NECTON PARISH COUNCIL RESPONSE TO BOREAS PINS QUESTIONS Deadline: 10th December 2019

URN: Q5.3.3 Requirement 16 Detailed Design Parameters

Title:	Scenario 1 Viewpoint 4: A47 Necton Substation
--------	---

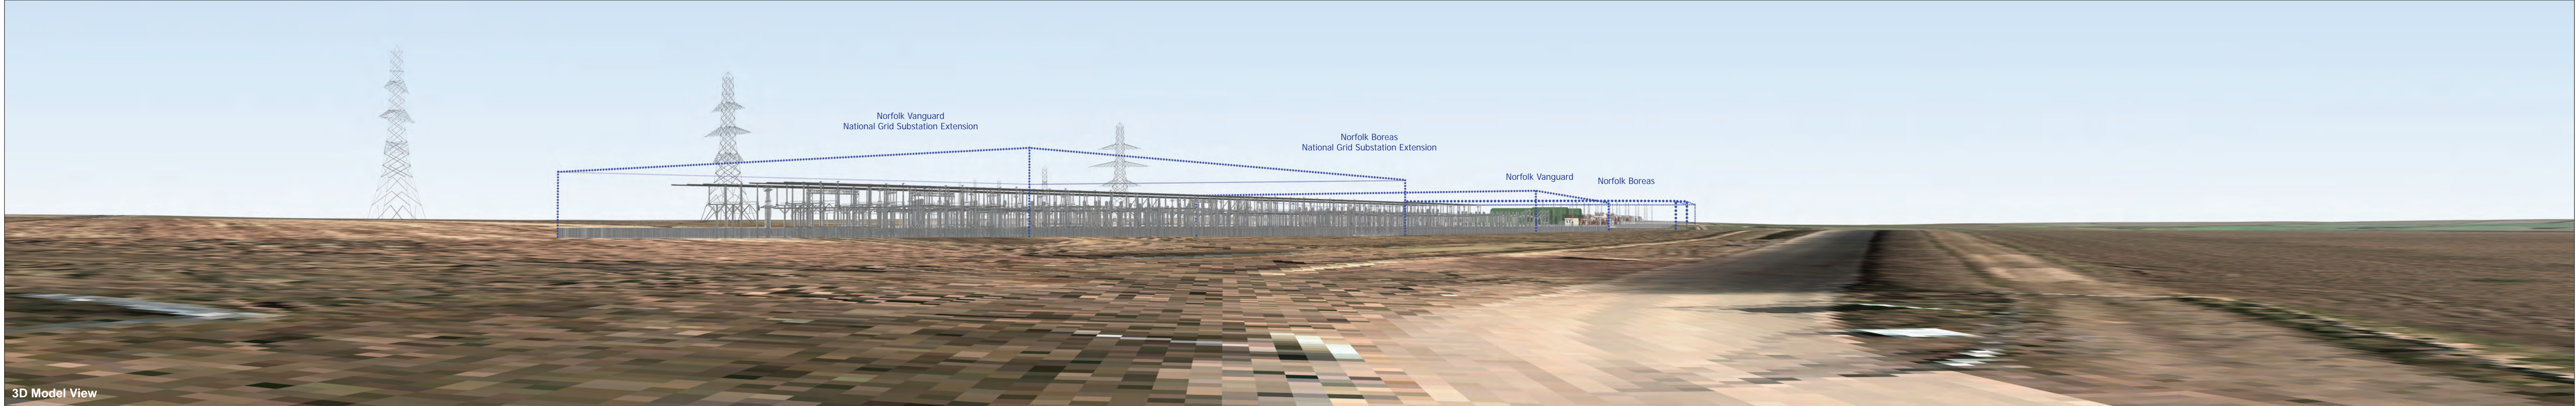
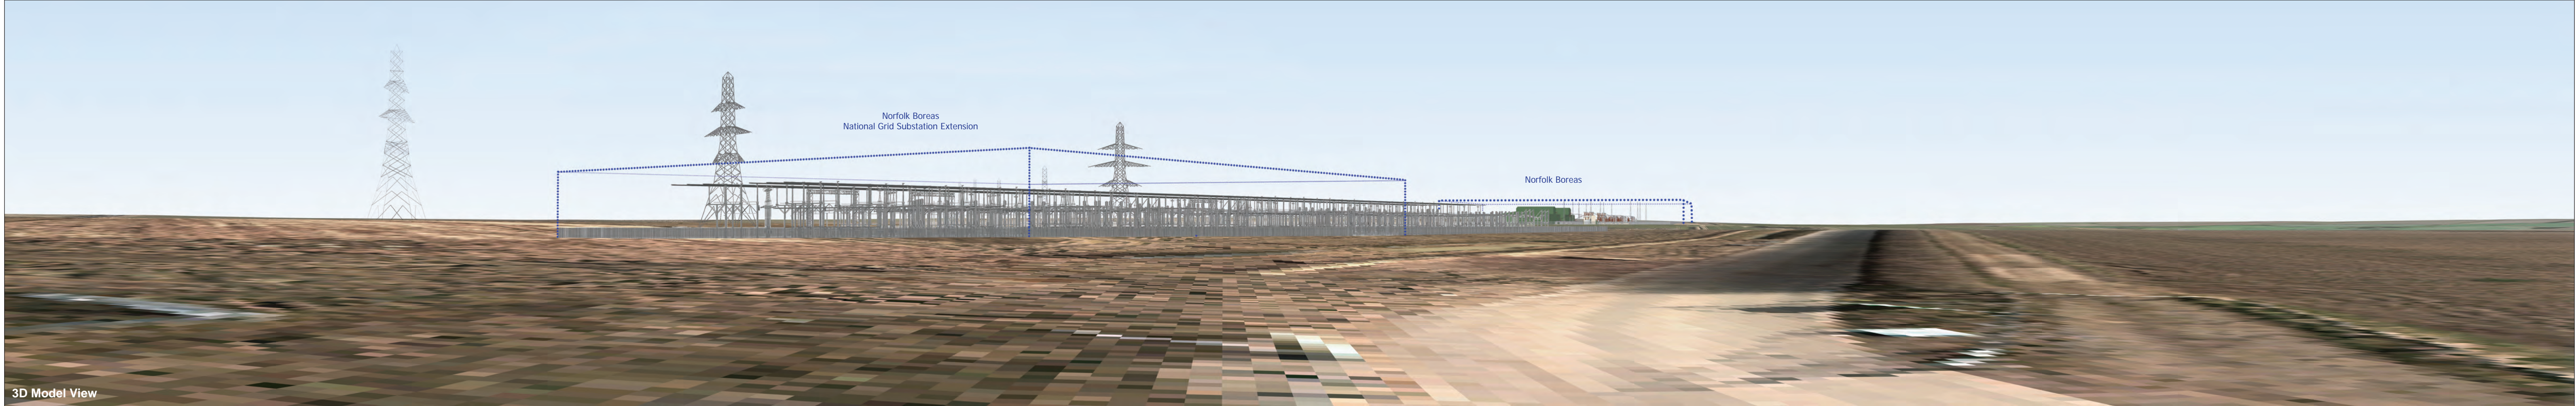
The design and access statement (DCO Document 8.3) contains very little information on the converter halls other than a limited description of the equipment inside. There is an indicative layout, coloured green, that has nothing to give any idea of scale. There should be a person / vehicle / London bus inserted into the montage to allow anyone viewing the document to get a realistic idea of what the building(s) will look like with reference to something whose size is already known. Also the 6m aerials appear to be missing.

We believe that all buildings should be restricted to a maximum height of 13m, including the converter halls. The land height should be lowered so the converter halls also meet the 13m height restriction. This will limit the visual impact on the village and surrounding rural areas.

National Grid have provided vague information and no visualizations of their installation. Consequently Necton Parish Council cannot make any reasoned comments. For a project of this size, more information should be made available and time given for assessments and comments to be made.

One matter that needs more investigating is the new tower / overhead line proposals for the Necton / National Grid site. Greater detail is needed. It could be that, if an NG L12 termination tower is required, this could be up to 50 metres tall (164 ft). Even a 'smaller' L6 tower could be around 30 – 40 metres tall (approx. 100 ft). We recommend that additional information regarding this apparatus is requested as the towers would dwarf the new substation site extension with no real possibility of screening.

Plate 8 Substation Footprint Options

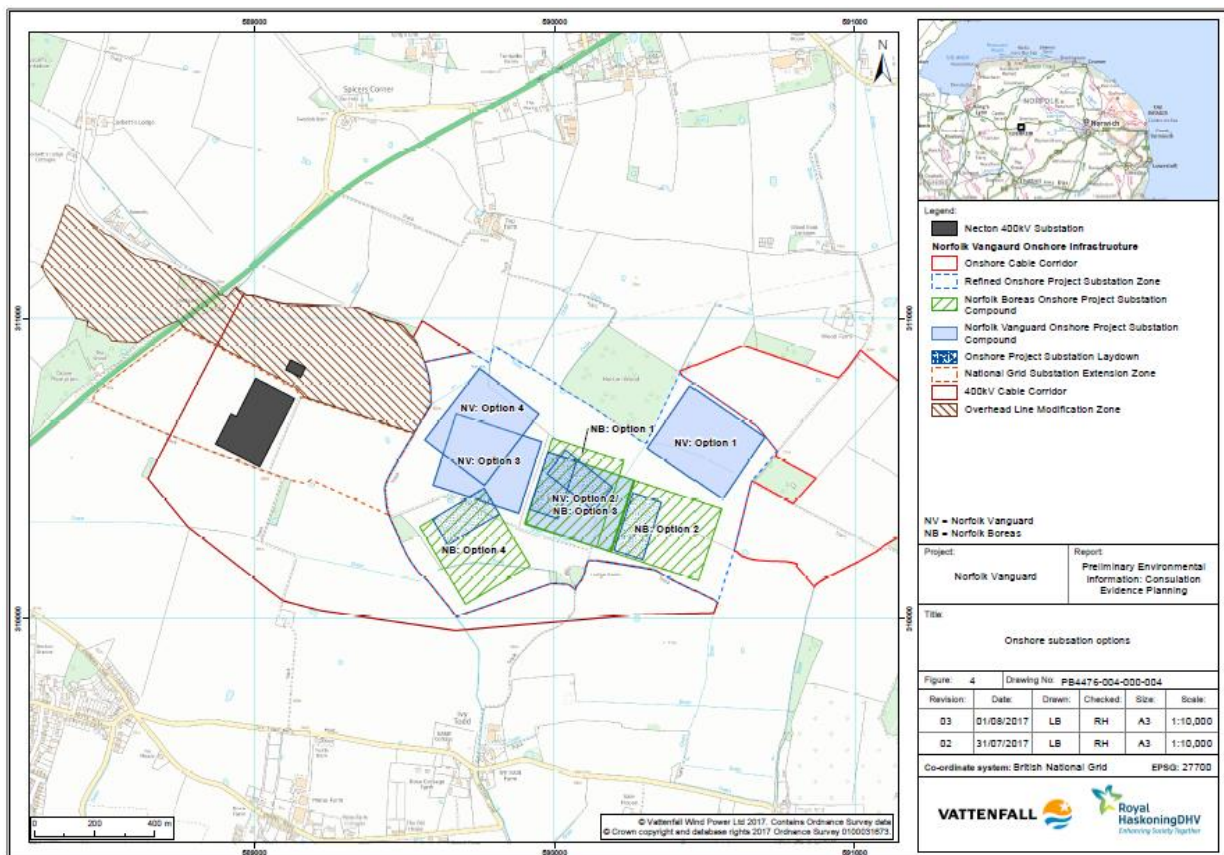
Only an indicative layout has been provided so far for the substations. This is not the first installation the Applicant will have carried out so there should be more

design details available that would allow an assessment of the quality of the design to be made. Necton Parish Council would appreciate more detailed information and the opportunity to make a reasoned comment on whether it can be classed as a good design.
